City of Sydney Review Response- Waterloo Metro Quarter

It is understood that after submission of the planning documents for the Waterloo Metro Quarter Development, commentary has been provided on the submission. The comments received are noted below, with commentary in response discussed in this letter. This document is an addendum to the submitted Appendix JJ – Central Precinct Landscape Design Report.

DRAWING NO.
WMQ-BLD2-ASP-LS-DRG-DA-301

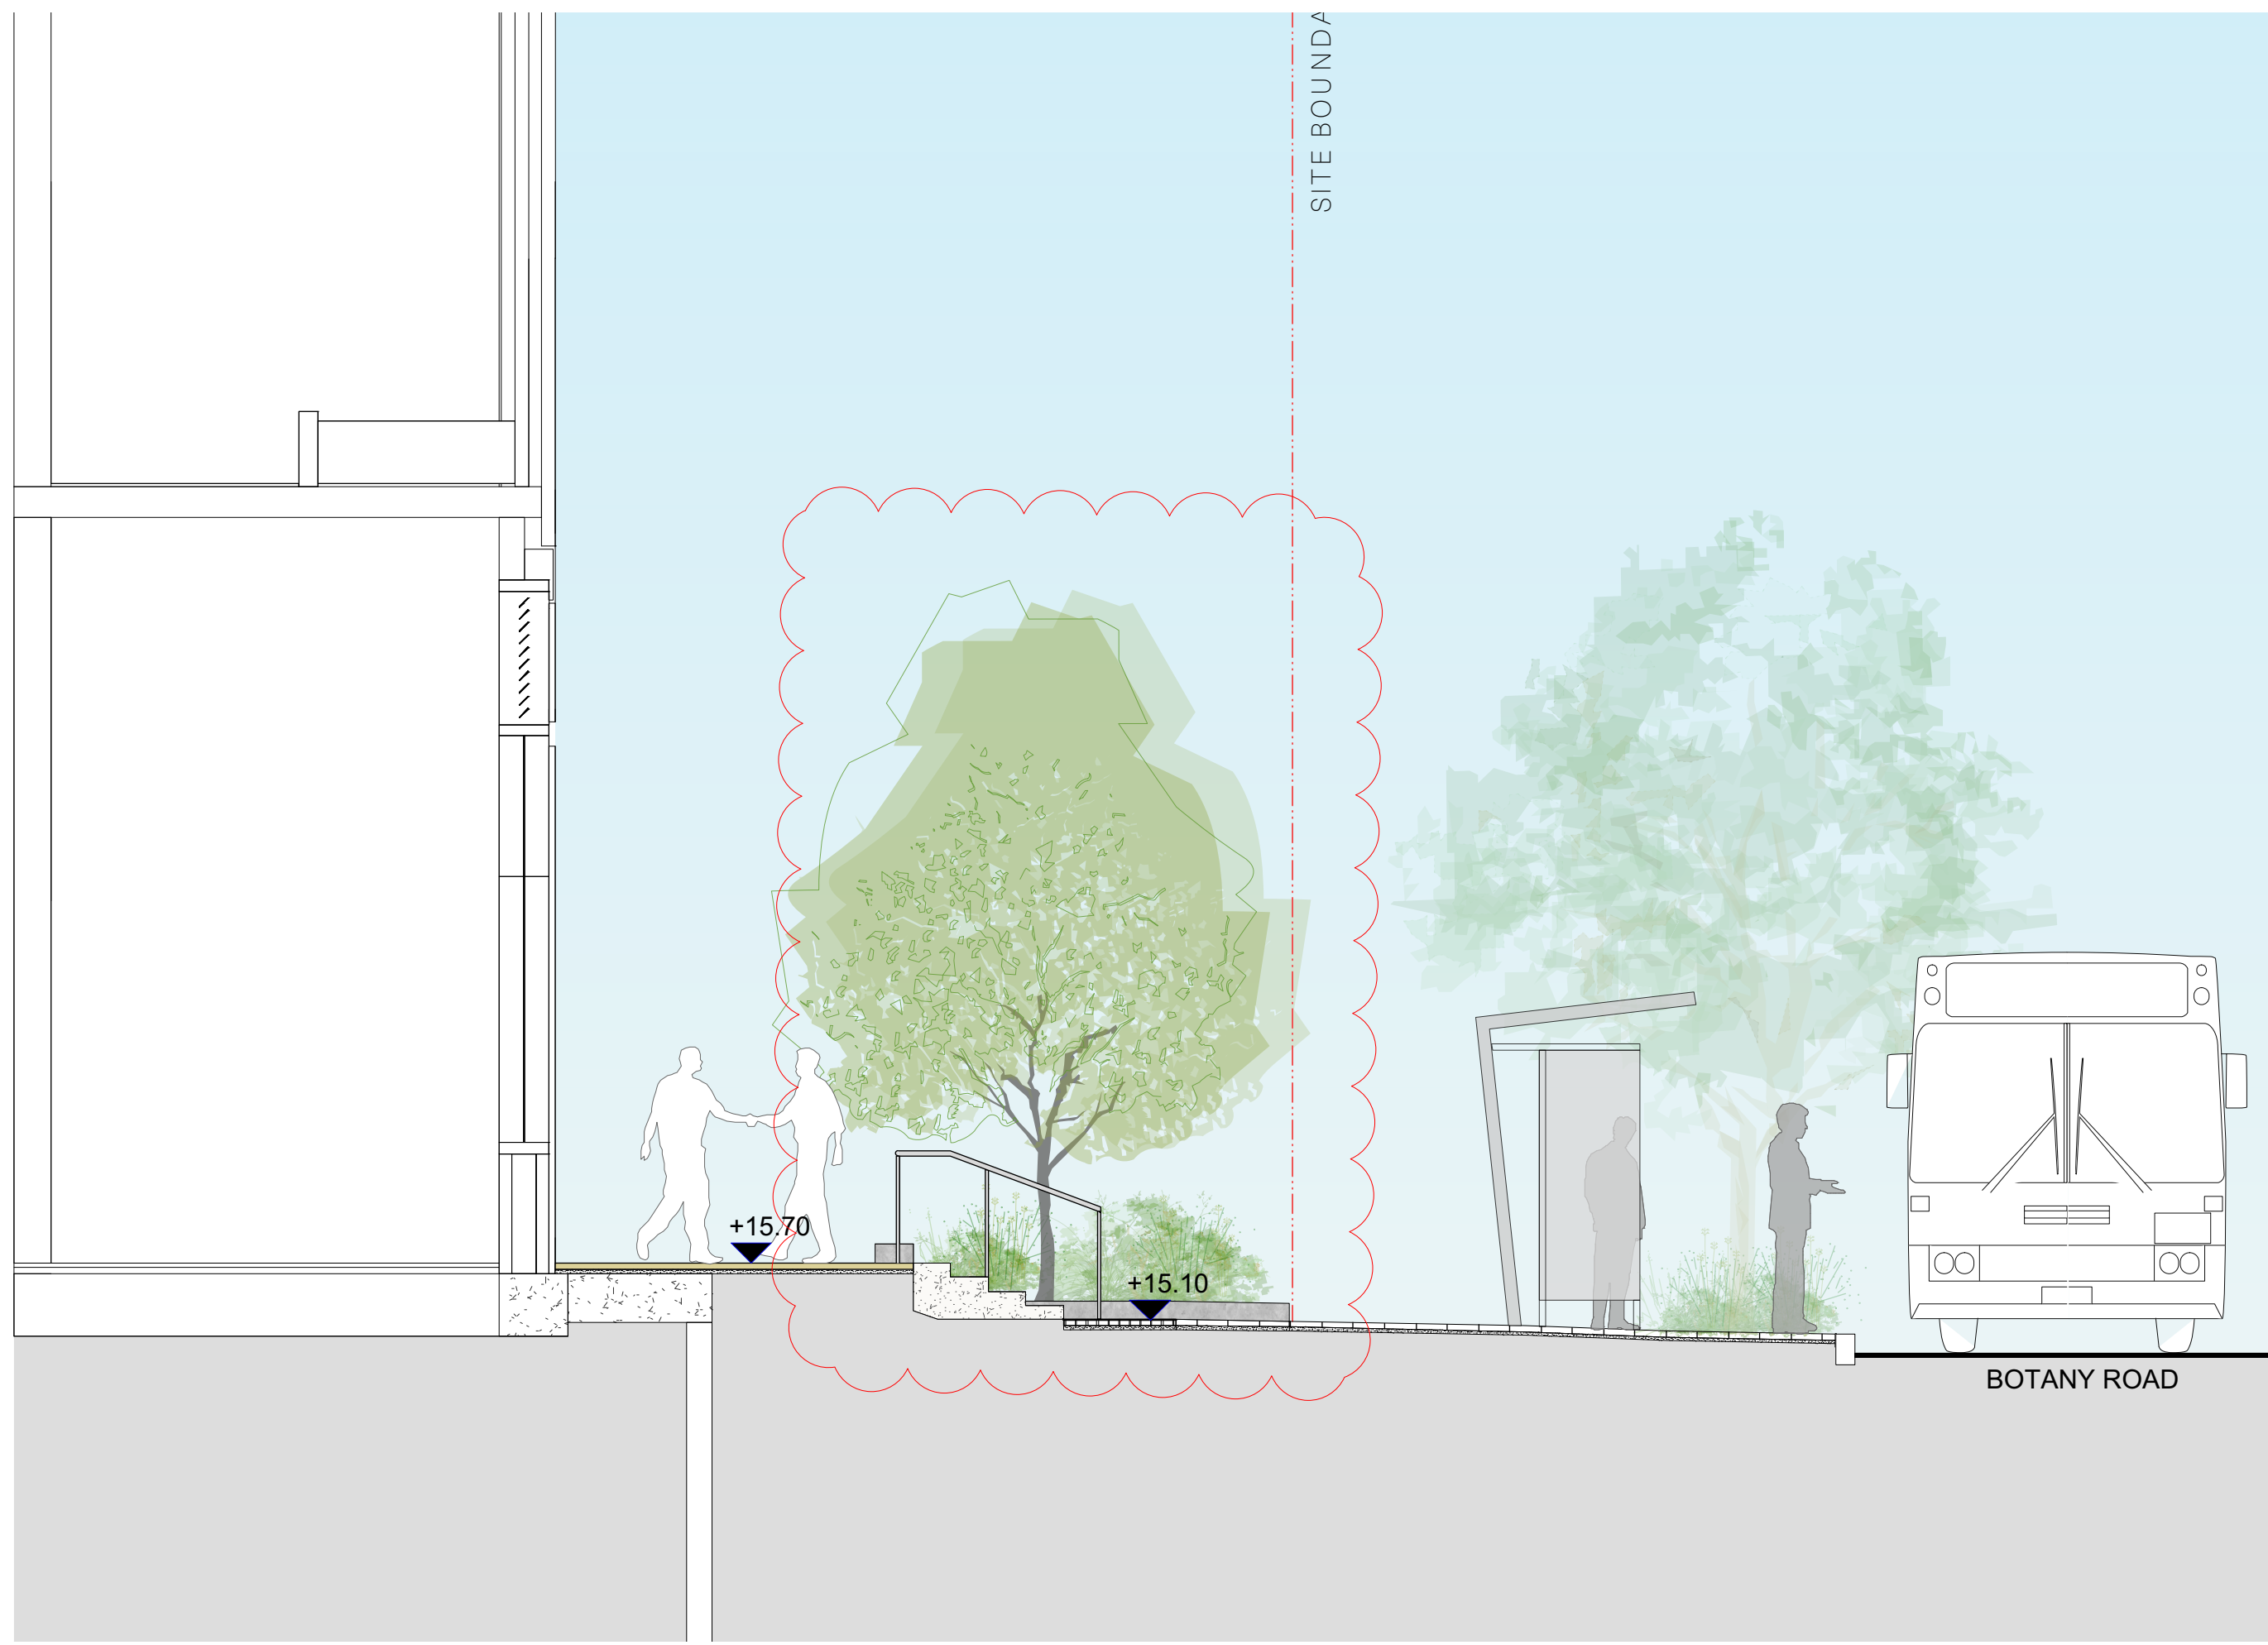
Landscaping		
36	<i>We request that the applicant provides top of wall levels to all walls, and more detailed spot levels across all landscape spaces on all buildings and ground level.</i>	All landscape plans have been updated to include more detailed levels information, providing top of wall and more detailed spot levels. Refer to Landscape Plans. <ul style="list-style-type: none"> • WMQ-BLD2-ASP-LS-DRG-DA-001 • WMQ-BLD2-ASP-LS-DRG-DA-002 • WMQ-BLD2-ASP-LS-DRG-DA-004
37	<i>The applicant is also requested to provide comprehensive landscape sections through all green roofs and accessible landscape terraces, demonstrating soil depth and build-up, as well as the interface with the building.</i>	Sections have been provided for all green roofs and accessible terraces, showing typical soil depths and interfaces with buildings. Refer to Landscape Sections. <ul style="list-style-type: none"> • WMQ-BLD2-ASP-LS-DRG-DA-300 • WMQ-BLD2-ASP-LS-DRG-DA-301 • WMQ-BLD2-ASP-LS-DRG-DA-302 • WMQ-BLD2-ASP-LS-DRG-DA-303
